From: Michael Eastham
Sent: 22 January 2018 11:36
To: Planning.Responses
Subject: FW: *EXTERNAL: LU/282/17/RES Courtwick

Please could you respond to the WSCC Local Highway Authority representation of **25th October 2017** and to the following objection:

Drawing No: 16.041.001

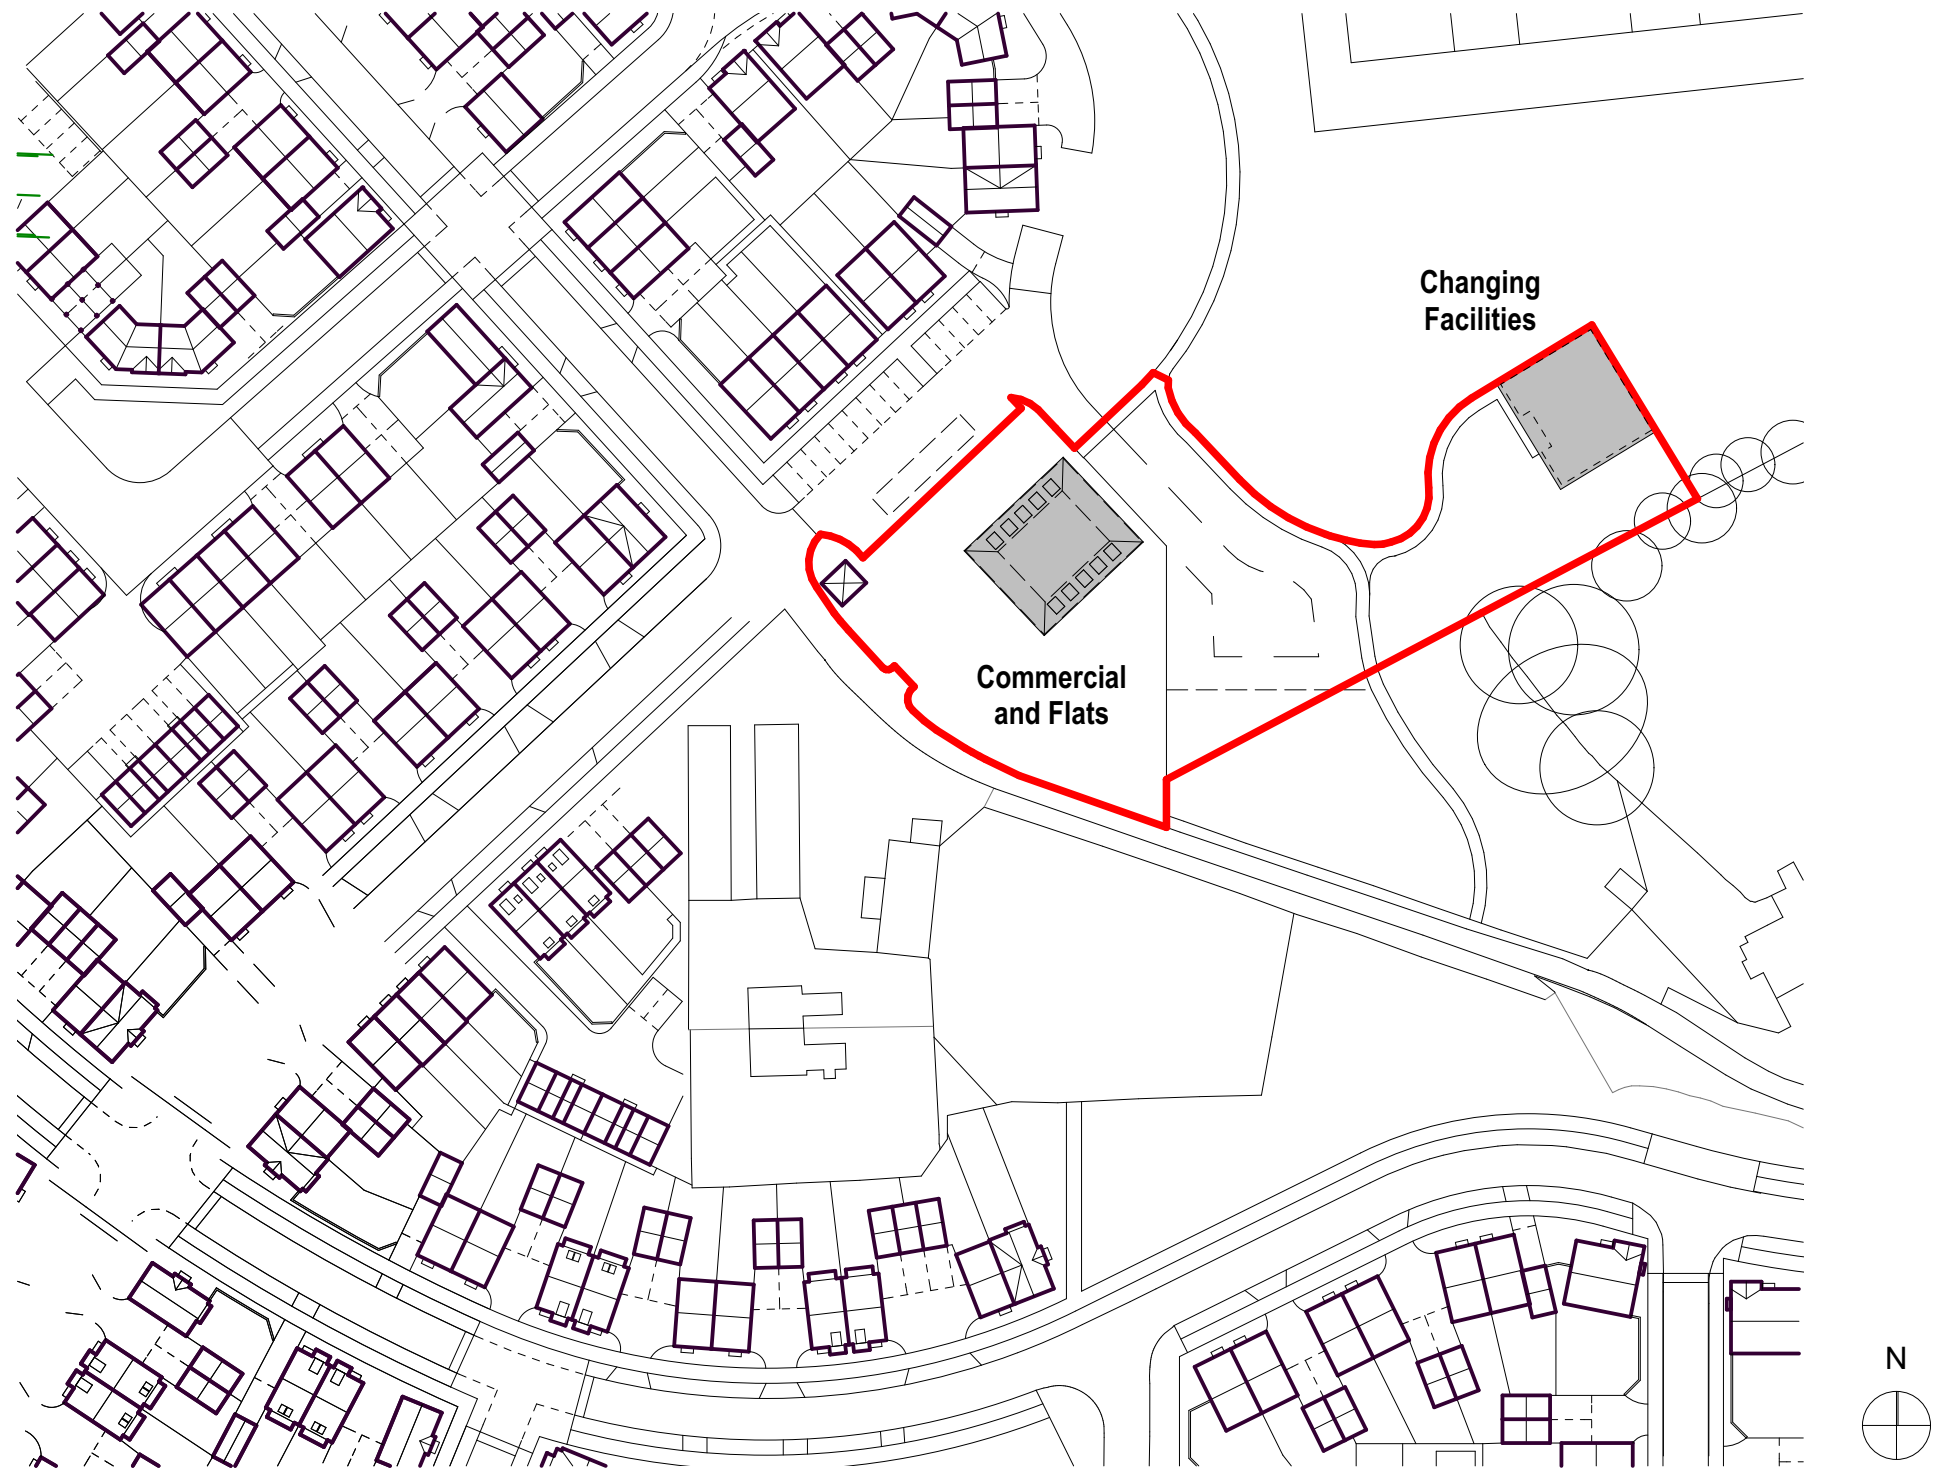
“Site plan drawing 16.041.002 Rev. B and the Location Plan drawing 16.041.001 Rev. A show an incorrect and out of date plan of the land surrounding the application site. The plans incorrectly show 8 properties and 14 parking spaces within the vicinity of the site of the proposed shops/flats. The Barratt site plan taken from their website shows 10 properties and 16 parking spaces opposite the shop/flats plus a further 8 properties that were approved as part of planning permission (LU/24/17/PL), adjacent to the site of the current planning application and missing from the site and location plan”.

I have now attached the official conveyance plan which confirms that the properties opposite the mixed use building are being built out and are reflective of the approved layout for Phase 2 (your ref:- LU/44/14 – drawing number P802/BAR/PH3&4/01C Planning Layout).
